WICKHAM MARKET PARISH COUNCIL

SIZEWELL C: Application for Development Consent Order DEADLINE 8 SUBMISSION 24th September 2021

Landscape and Visual matters SP&R

DRAWING TITLE:  
 SOUTHERN PARK AND RIDE PROPOSED PARAMETER PLAN

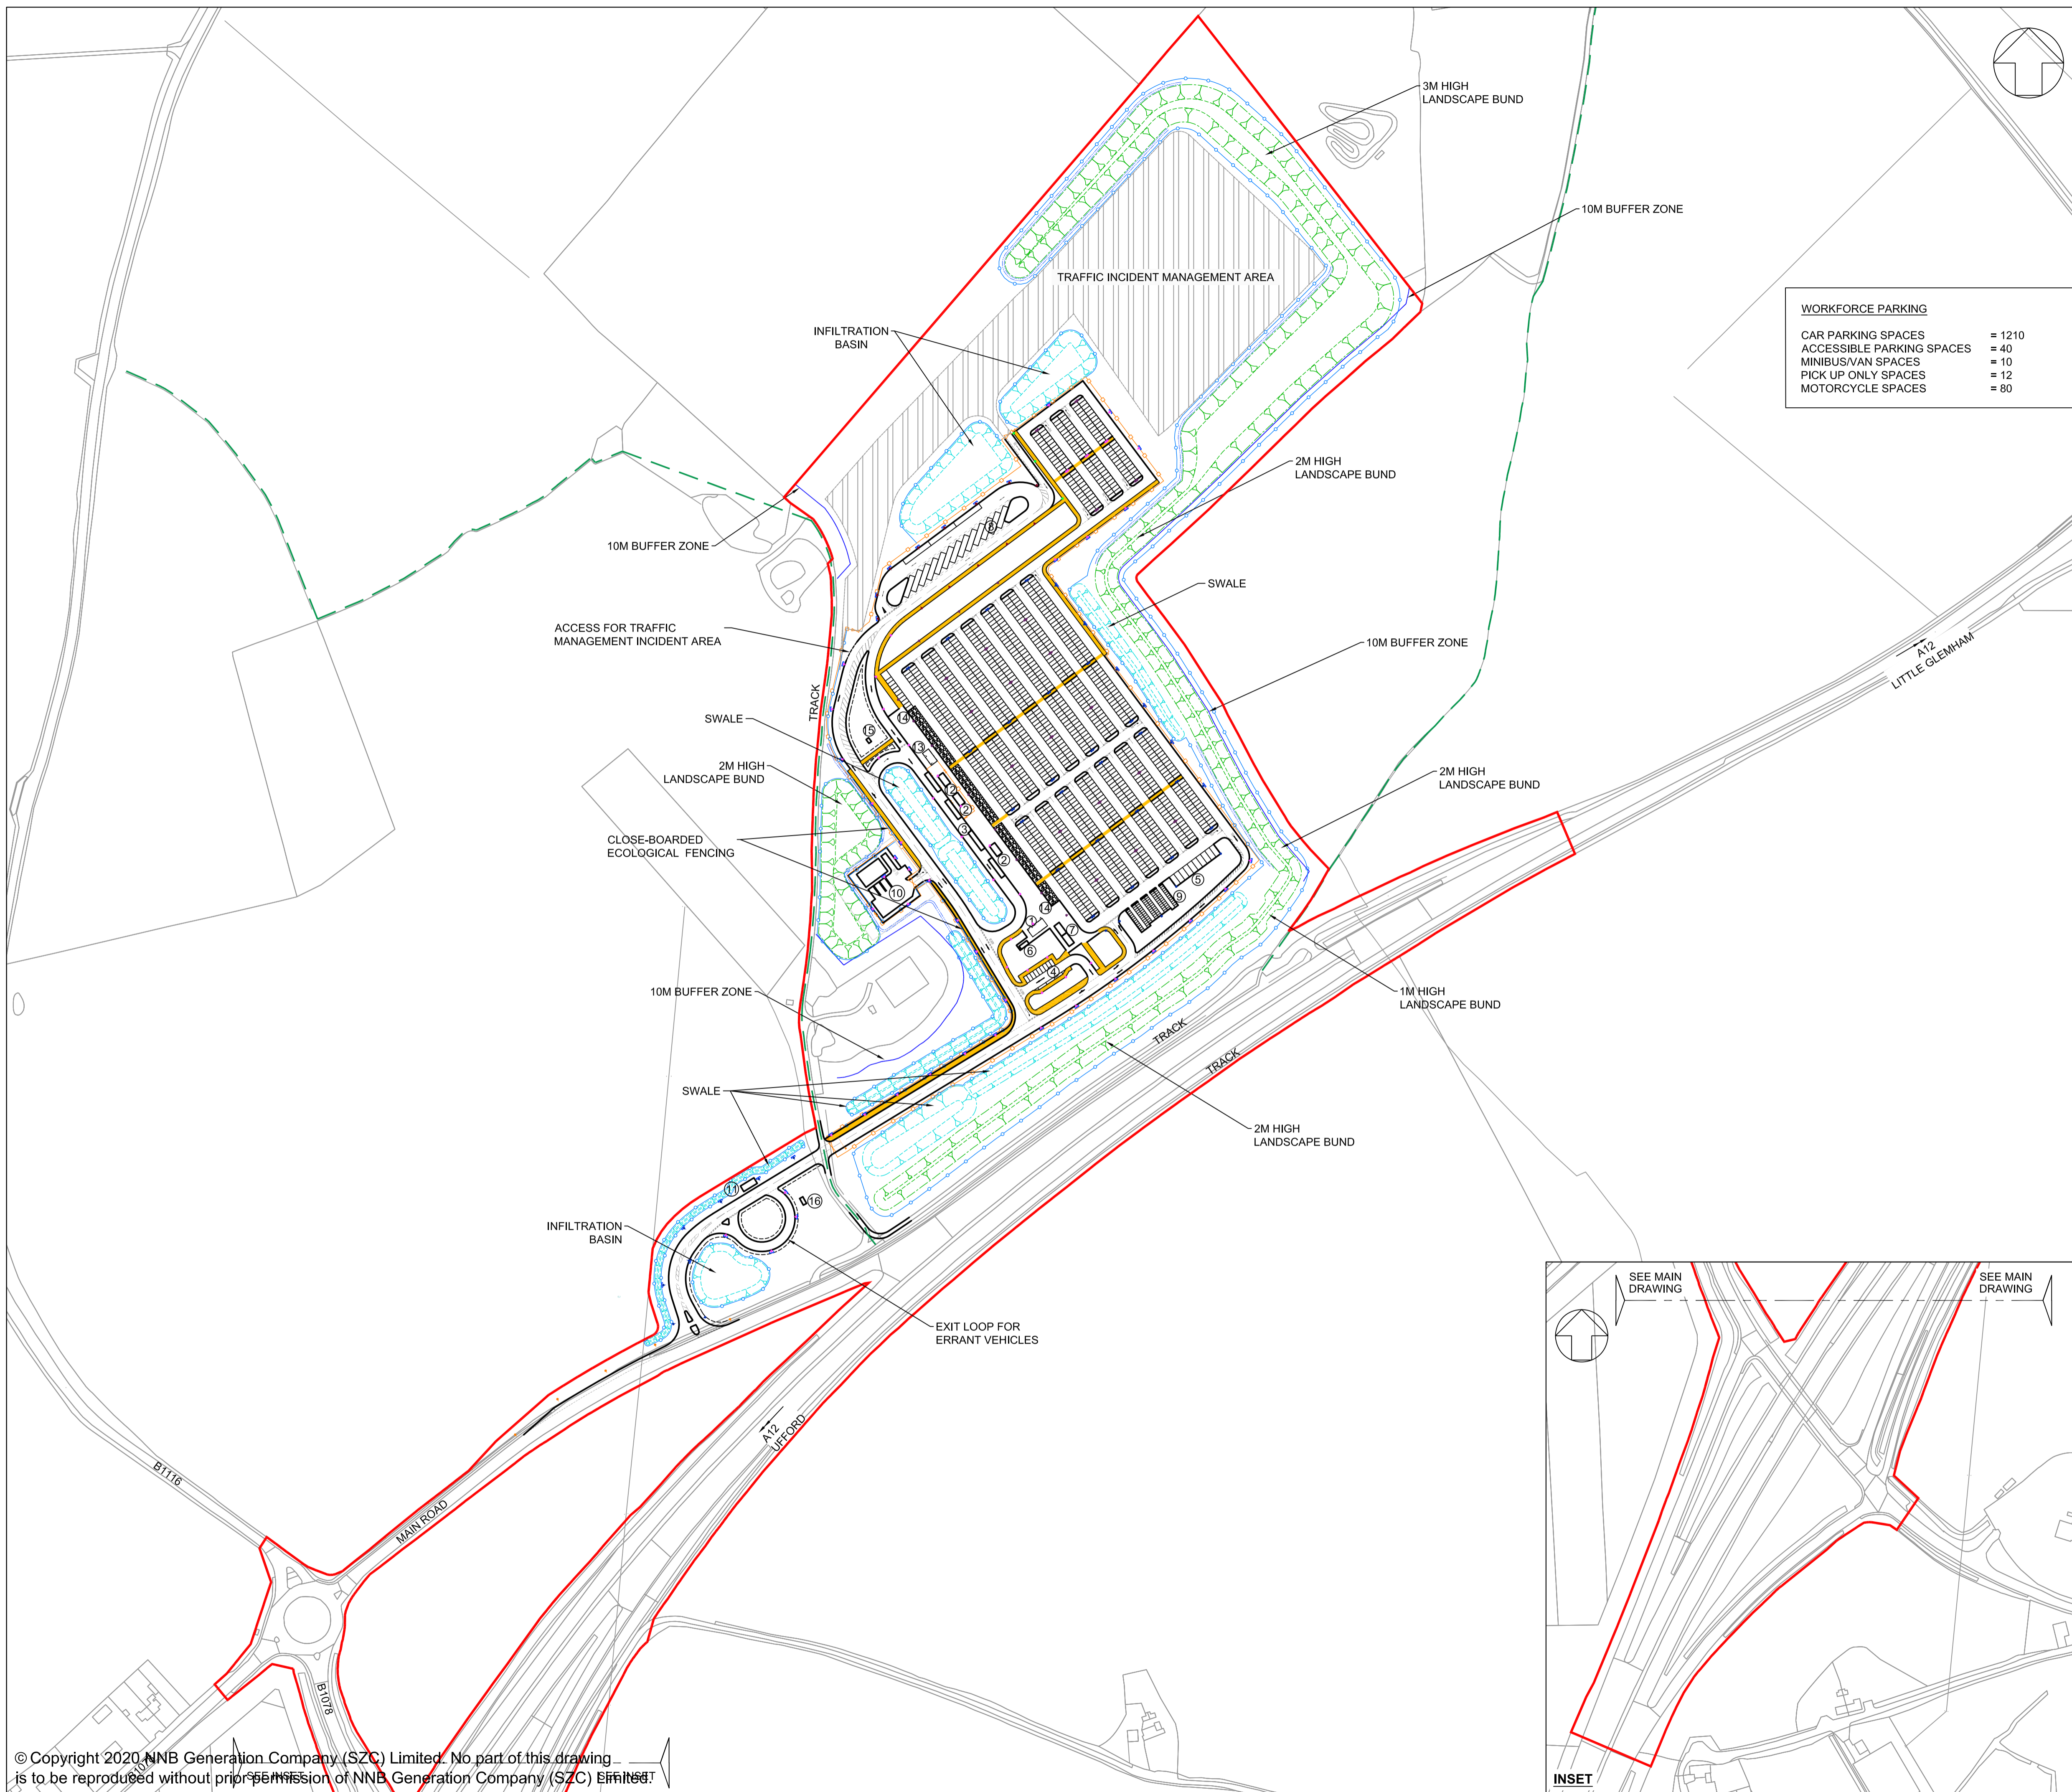
- Lack of detail relating to the TIMA site area, access, space for landscape mitigation on the western flank, capacity (no layout included), lighting impacts, lack of use criteria, operational management and monitoring of use. We request that the ExA apply appropriately worded and stringent conditions (if ExA are minded to recommend approval).

- The west site boundary/Bridleway 8 remains an area of serious concern where there is a lack of space for any effective screen planting. For a distance of approx. 150 metres there will be clear views into the site (Hacheston and B1116), the car park, coach parking and TIMA.

**DRAWING TITLE:**  
 SOUTHERN PARK AND RIDE PROPOSED LANDSCAPE MASTERPLAN AND FINISHED LEVELS

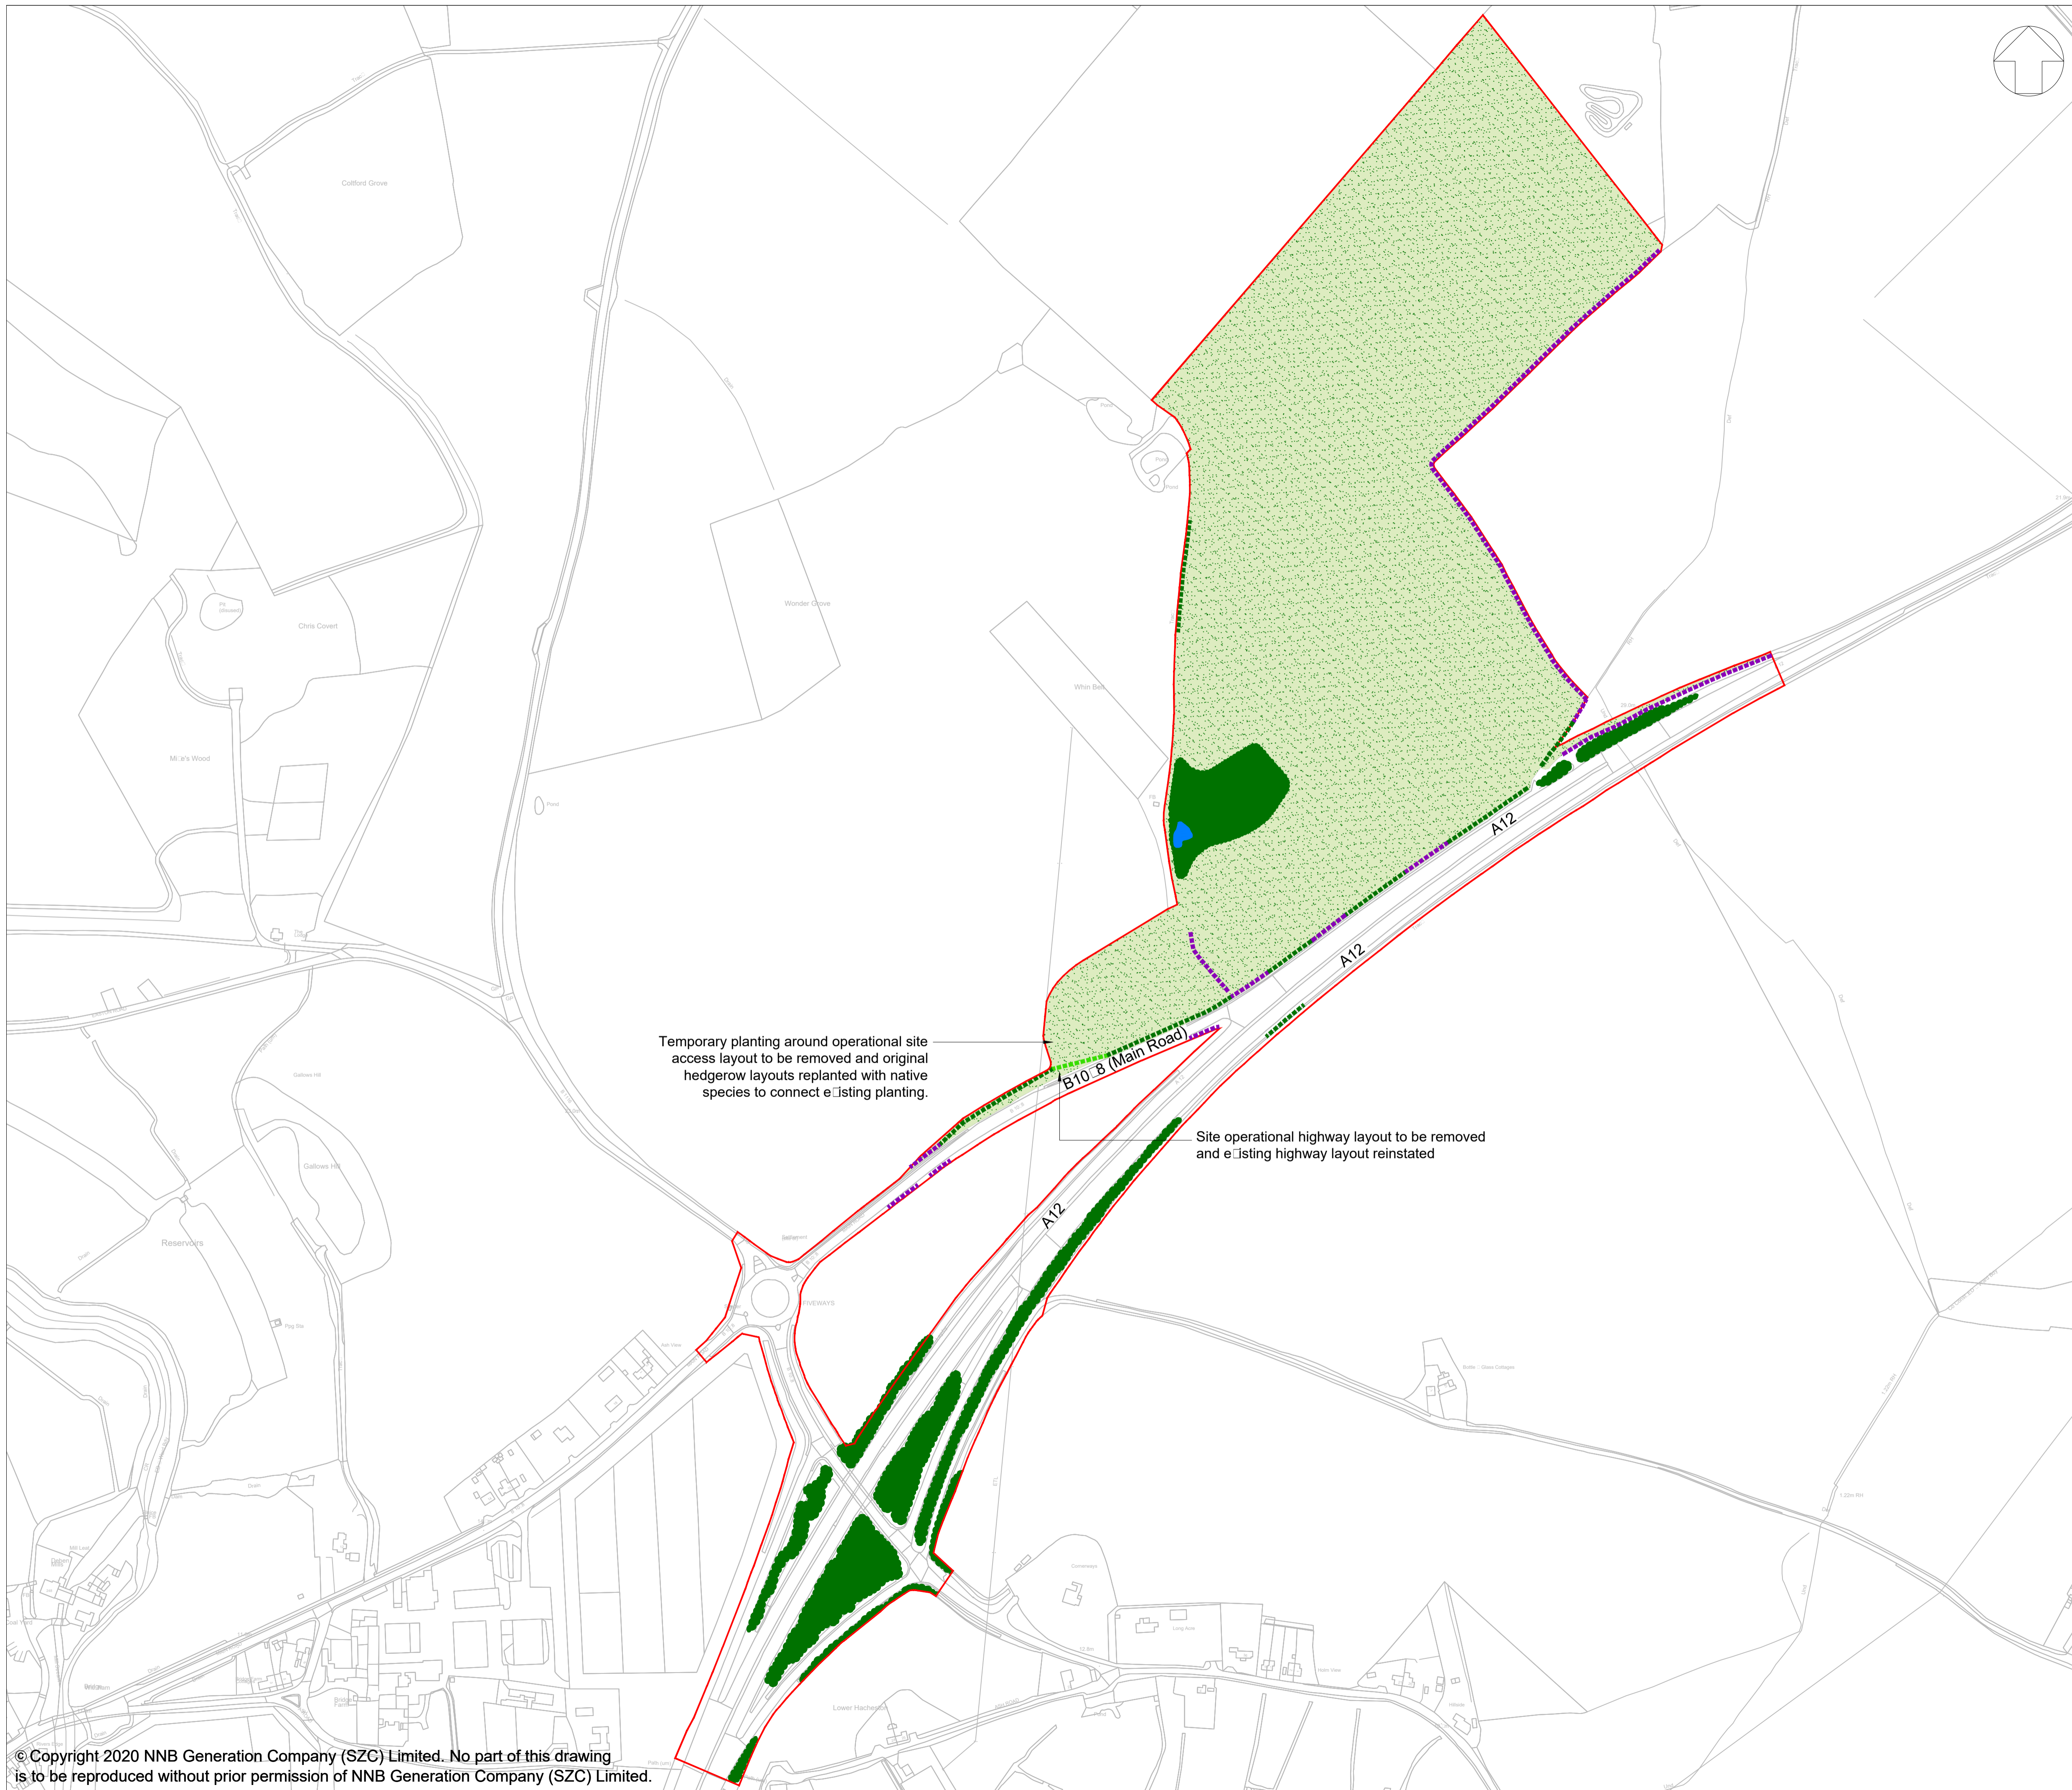
- Lack of detail and commitment regarding the landscape mitigation in the area of the site access and slip road, including lack of detail relating to cycle and footway access.

- We have requested that opportunities for off-site planting secured by the S106/or Deed of Obligation be explored to provide some screening and a long-term legacy of landscape enhancement within the vicinity of the SP&R site.
